CITY OF ALBUQUERQUE

March 29, 2021
Mathew Vallejos
Green Globe Environmental, LLC
PO Box 400
Los Lunas NM, 87031

**Re: Cinnamon Morning - 2714 Rio Grande
Erosion and Sediment Control Plan
Engineer's Stamp Date 3/16/2021 (G12E024)**

ESC-1

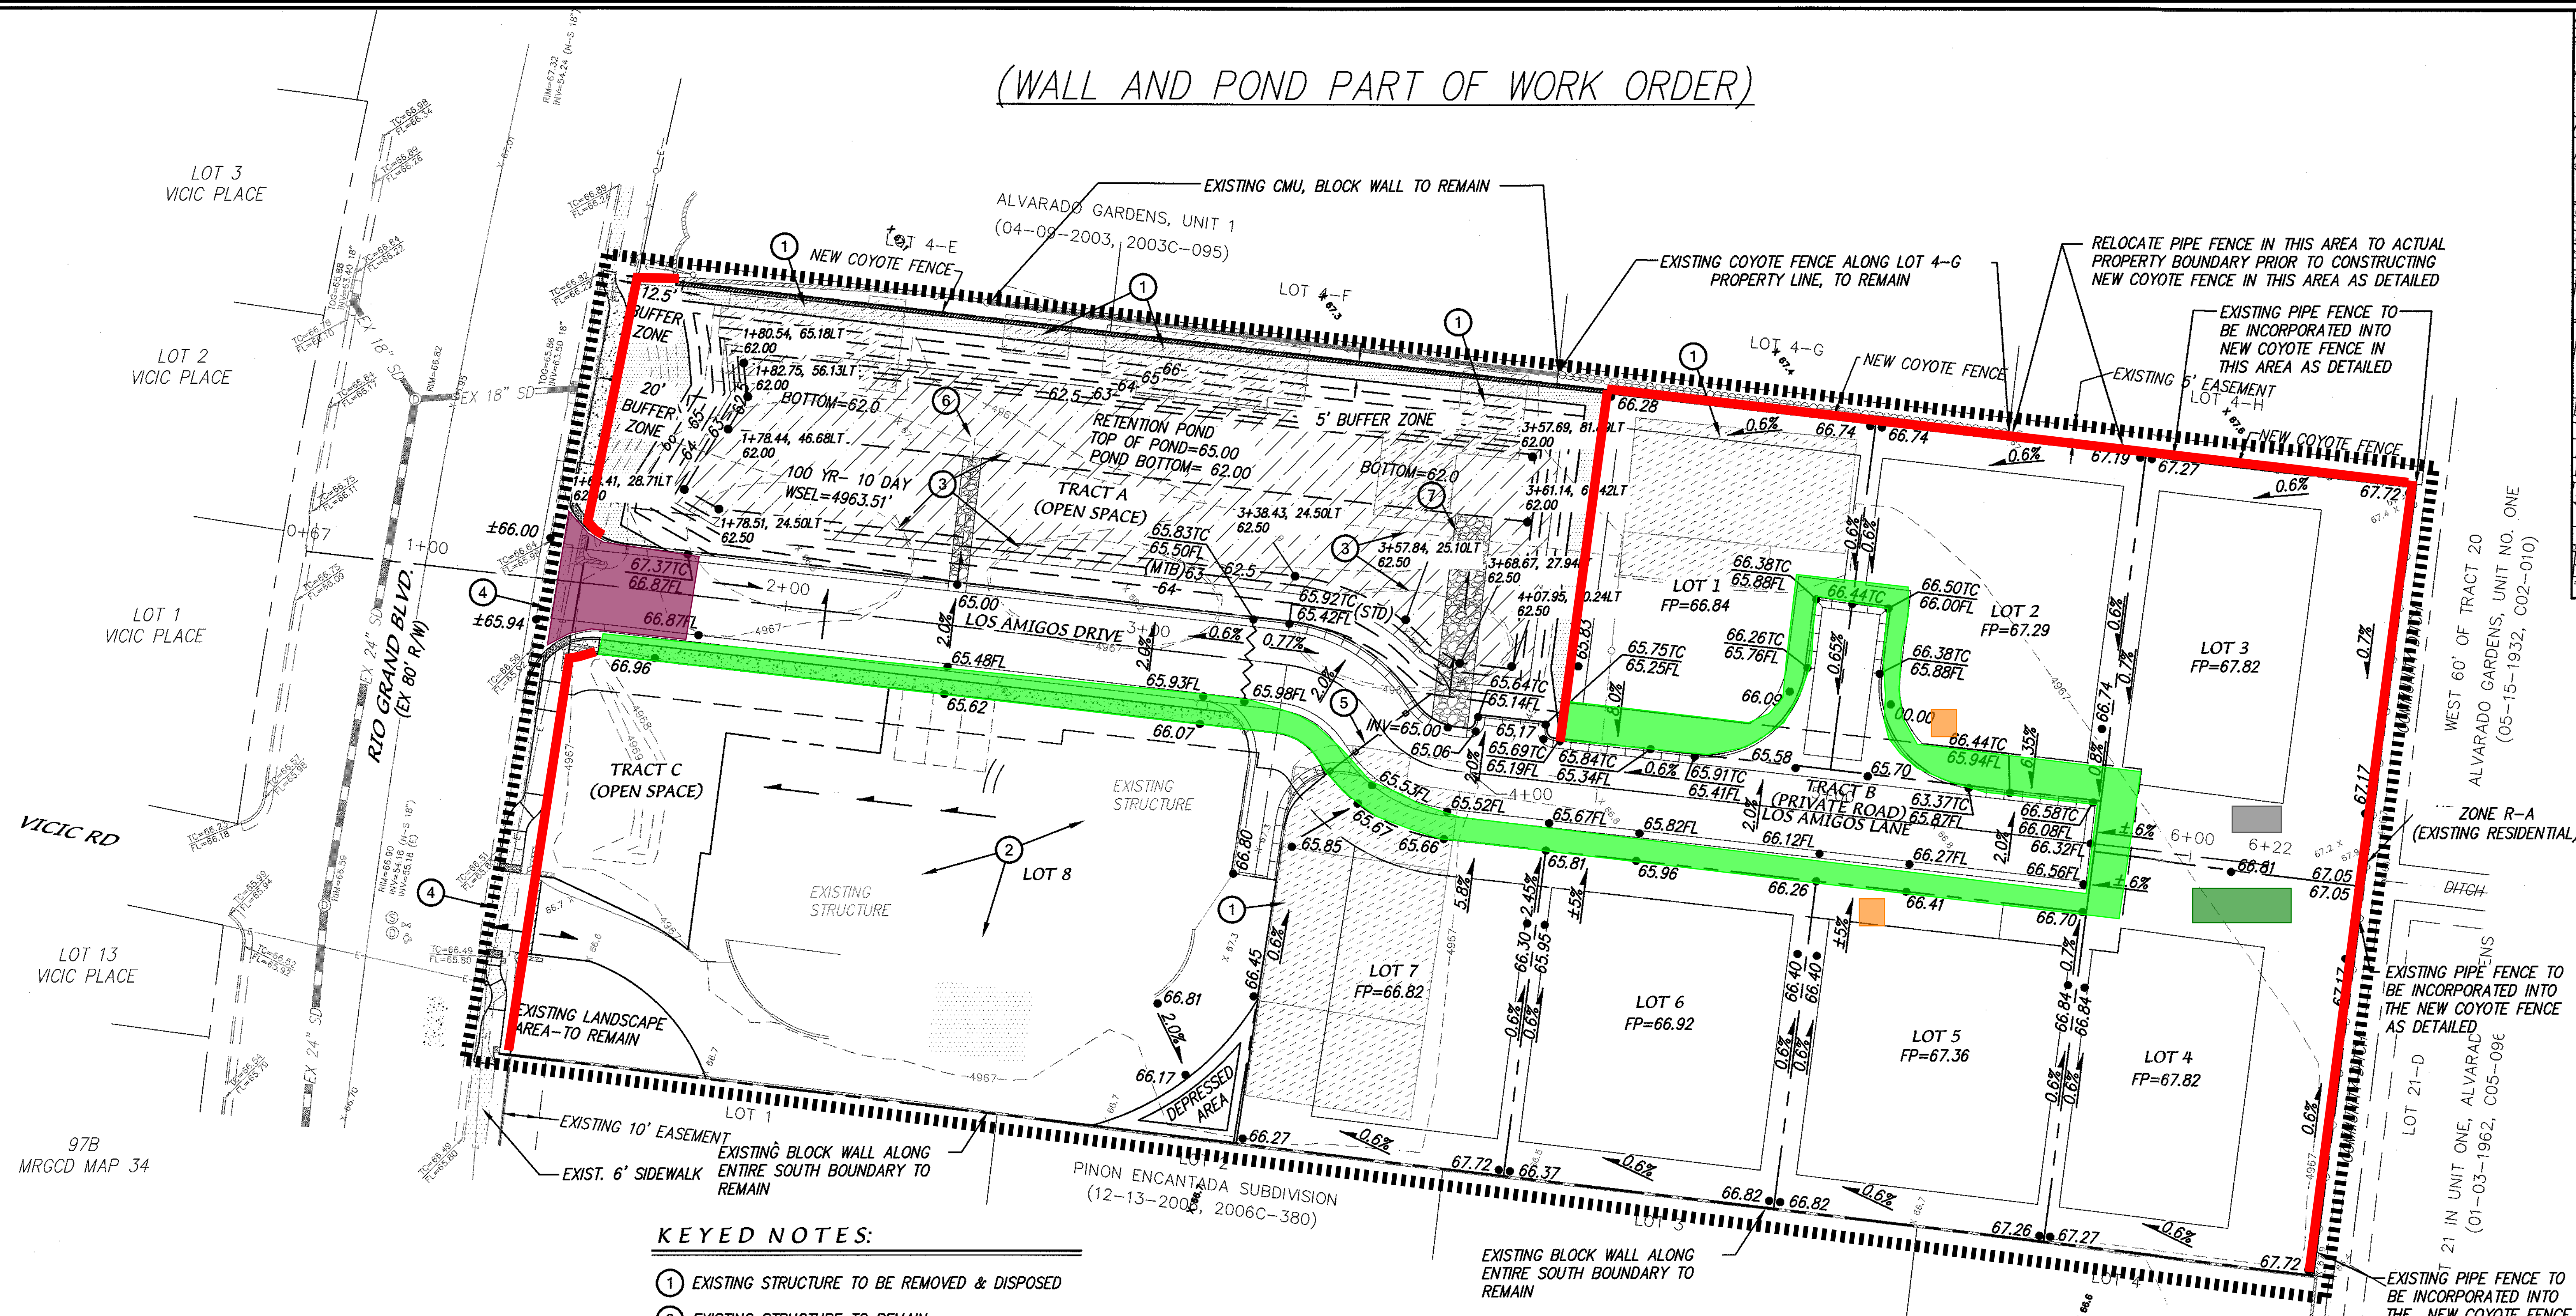
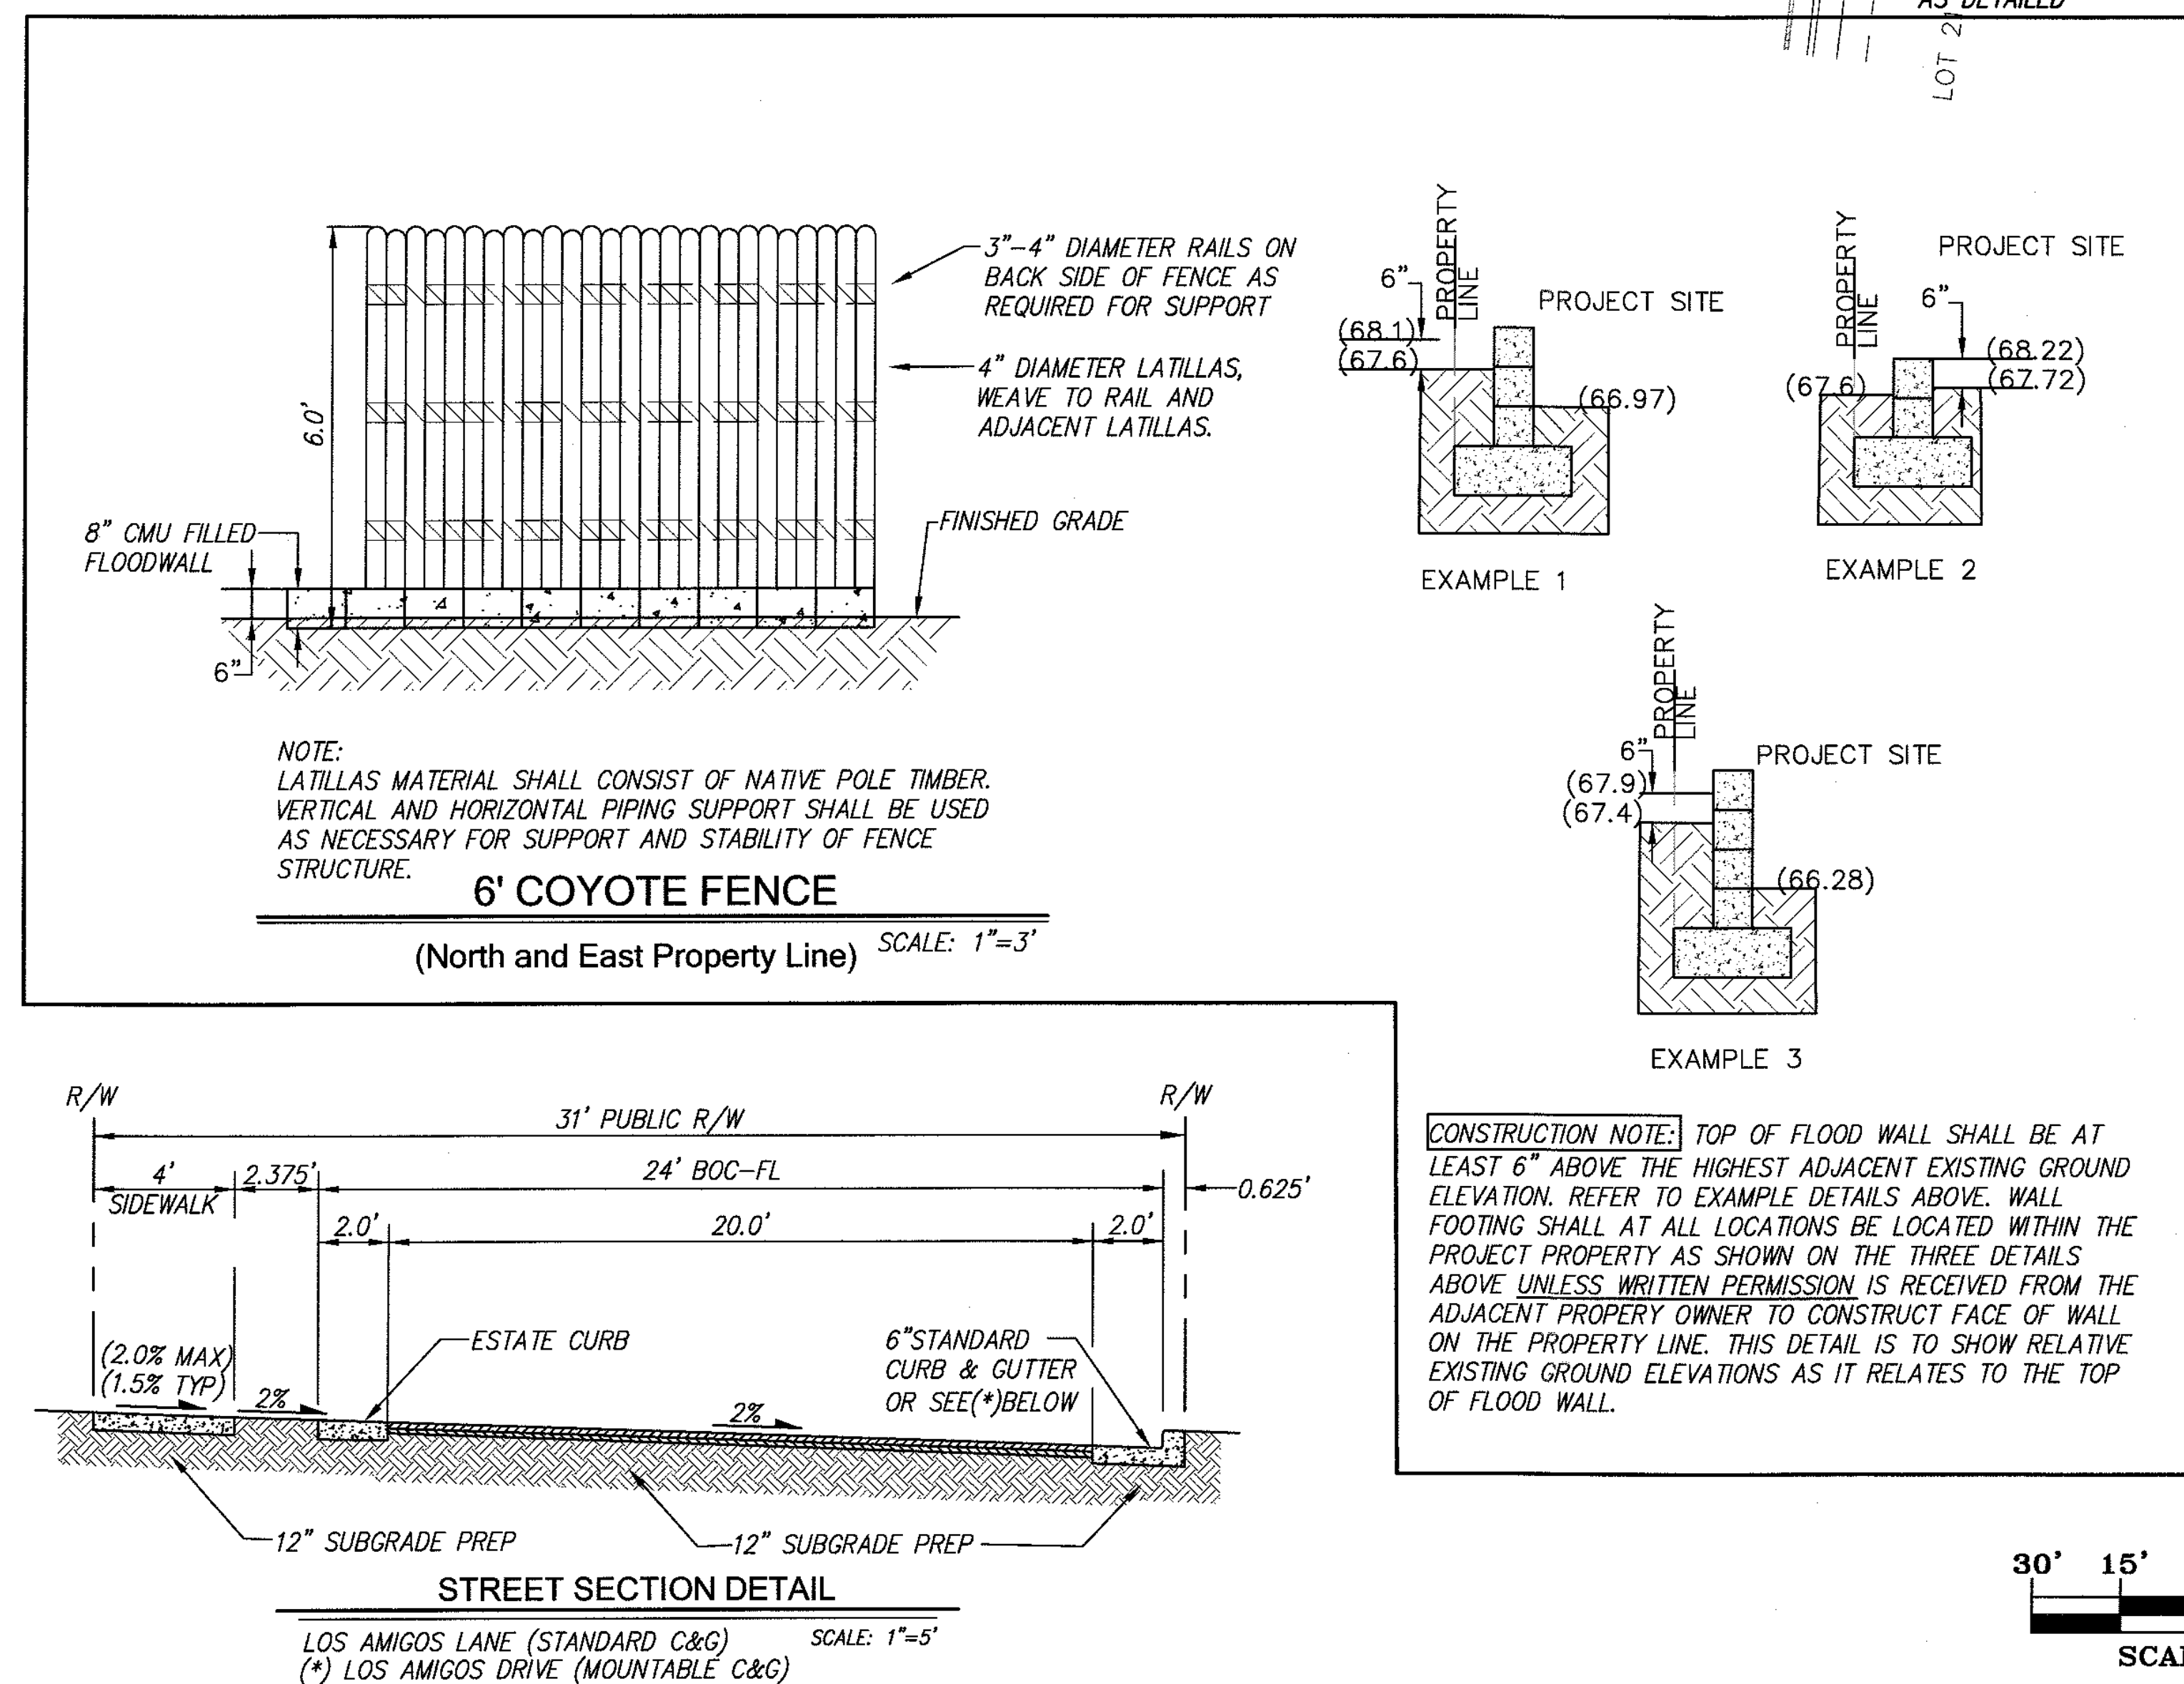
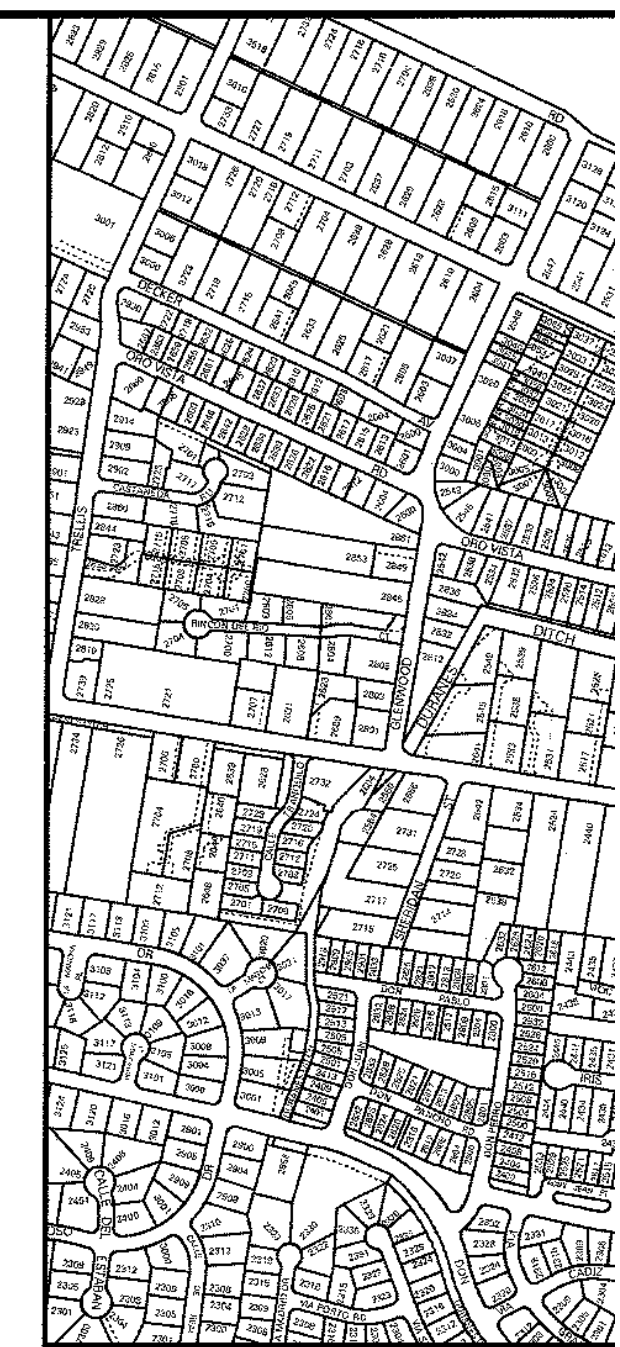
1. The Limits of Disturbance should exclude lot 8 all except the depressed area in the south east corner of lot 8. Please adjust BMPs accordingly.
2. List operators on the plan, including name, phone #, and e-mail address. If unknown, leave blanks to be filled in later (CGP 7.2.1);
